Application No: WA/9/22/HH
Site Address: Midway Avisford Park Road Walberton BN18 0AP
Description of works: Single storey rear extension.

Thank you for your internet representation made on 23rd March 2022 which has been recorded as an objection with the comments as follows:

PROPOSED FLOOR PLAN

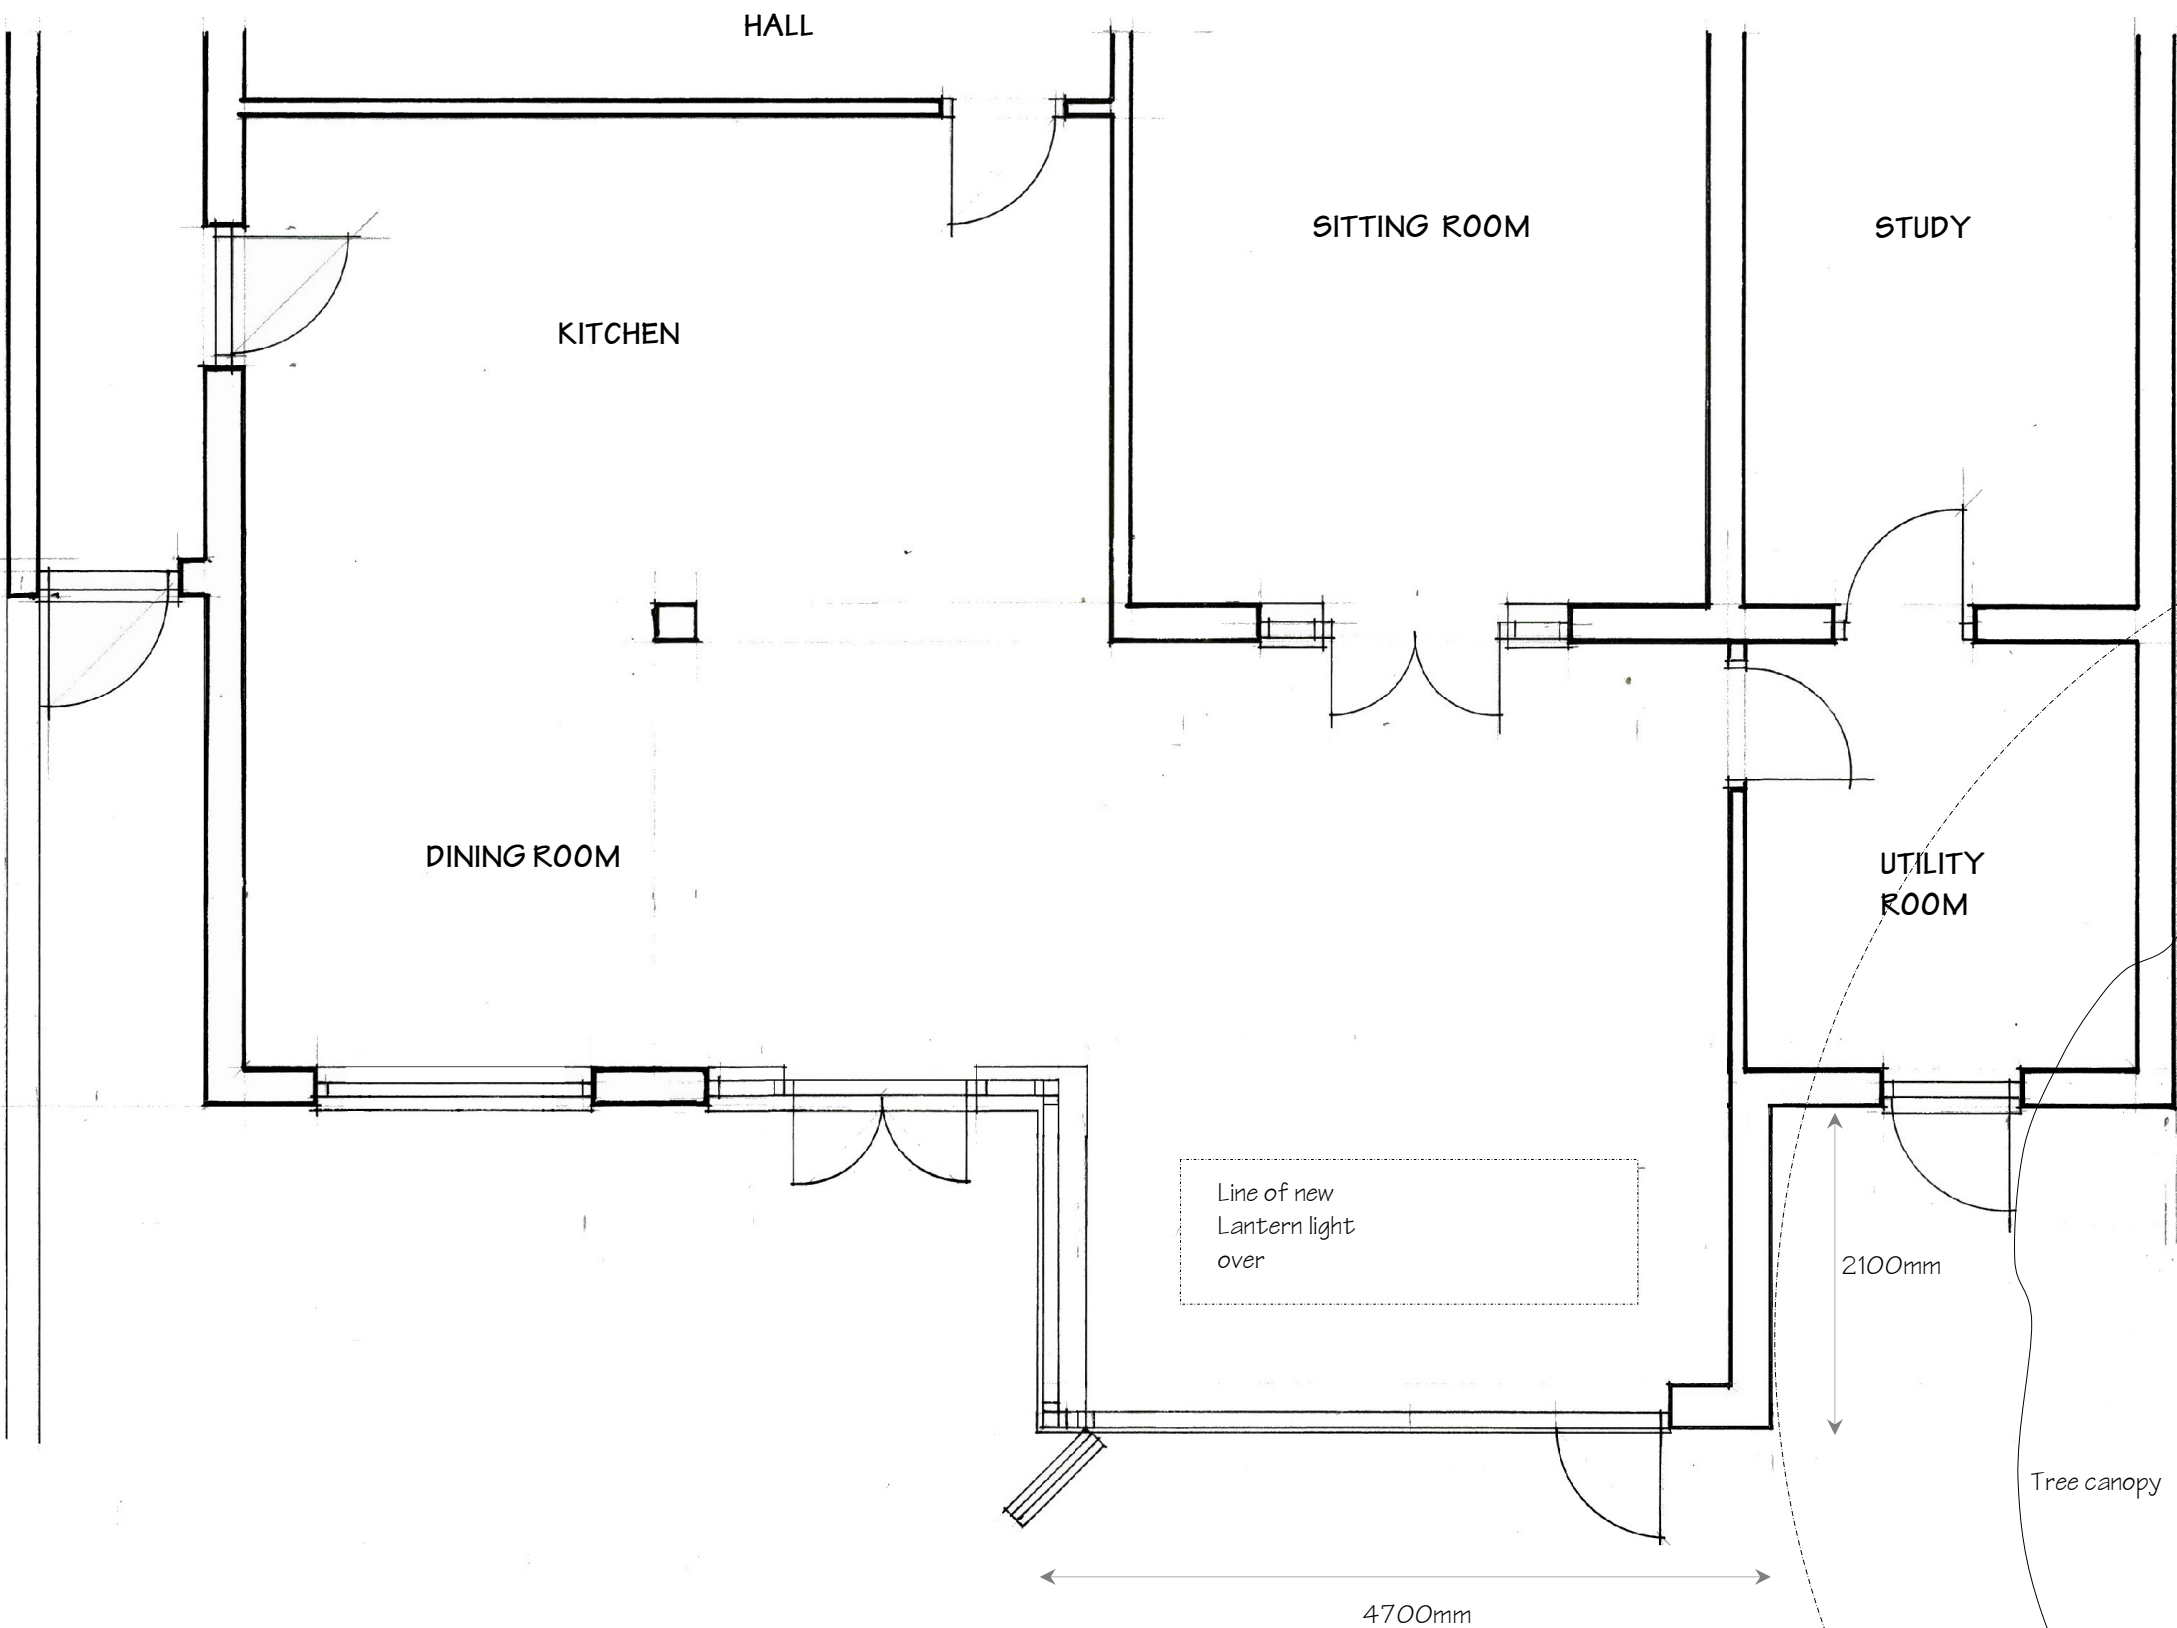
It also looks unrealistic and misleading that the Proposed Floor Plan shows the Root Protection Area ending exactly where the new building starts.

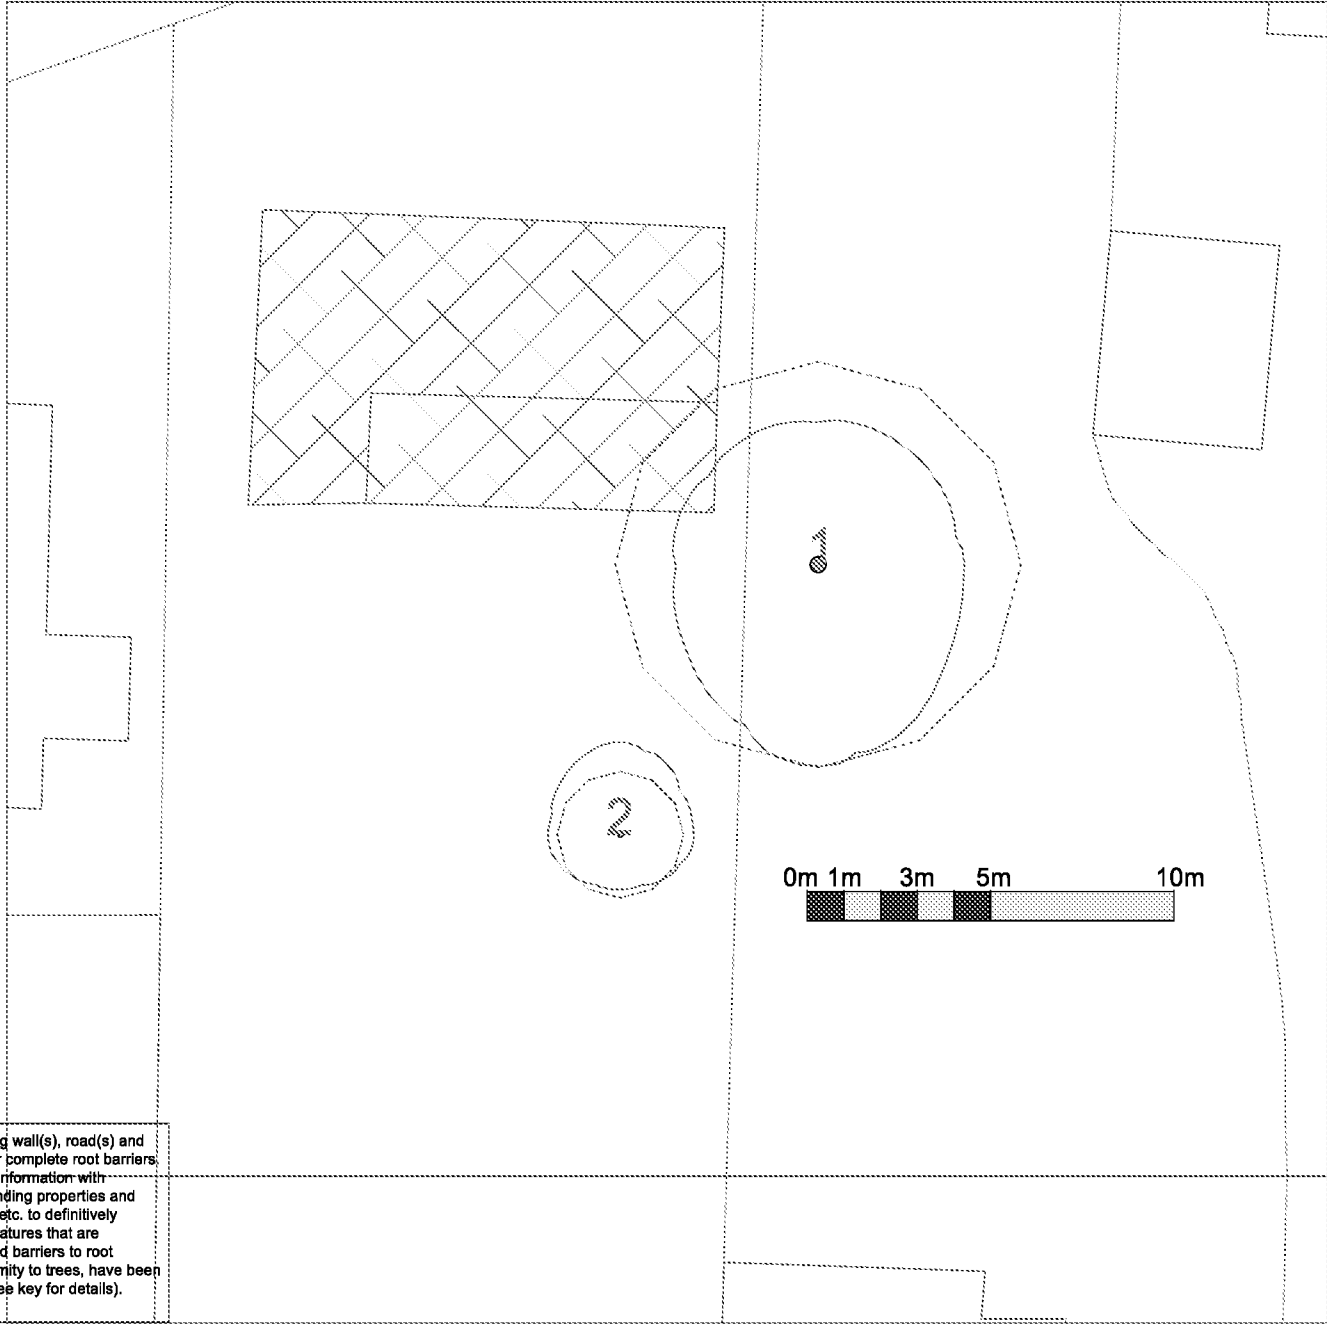
They further cite lack of information about barriers to root spread in their Tree Constraints Plan, but clearly there is no built obstruction to prevent root spread in the direction of the extension and no indication that a soil sample was even taken.

The TPO tree trunk diameter is substantial, clearly demanding a proper survey. In fact the estimated stem diameter given is grossly underestimated, at 450mm.

*The actual diameter of the trunk at 1.5m height from the ground is 611mm

*The actual circumference of the trunk is 1920mm
